Please ask for: Mrs D Johnson
Email: daun.johnson@arun.gov.uk
Telephone: 01903 737762
Our Ref: WA/36/21/PL
Your Ref:
Date: 6th May 2021

Application for Planning Permission

Development: Rear extension, attic conversion & conversion of shop front to form part of single residential dwelling. This site is in CIL Zone 2 & is CIL Liable as new dwelling.
Location: 3 Orchard Crescent Arundel Road Fontwell BN18 0SD

BLOCK PLAN
1:500@A3

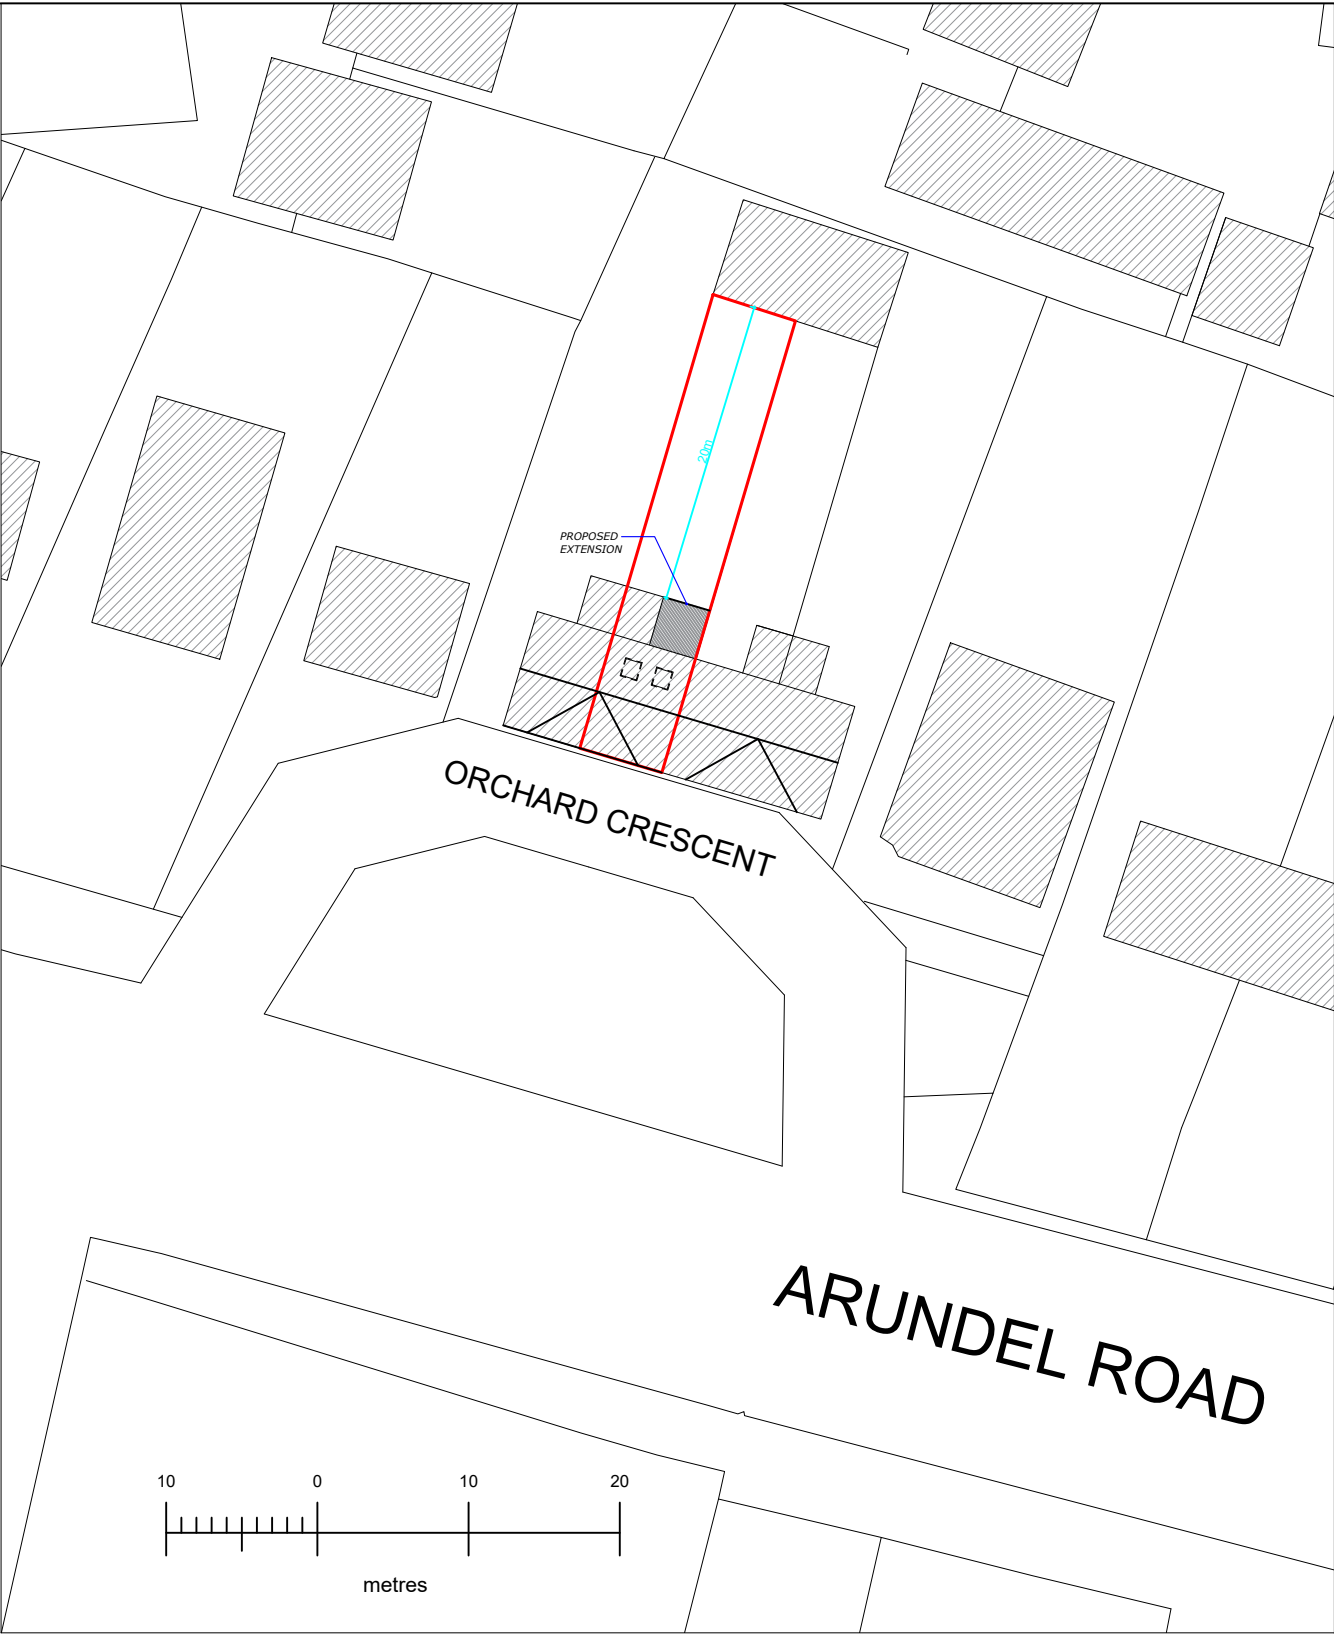
Please provide a North point on the Location and Block plan.
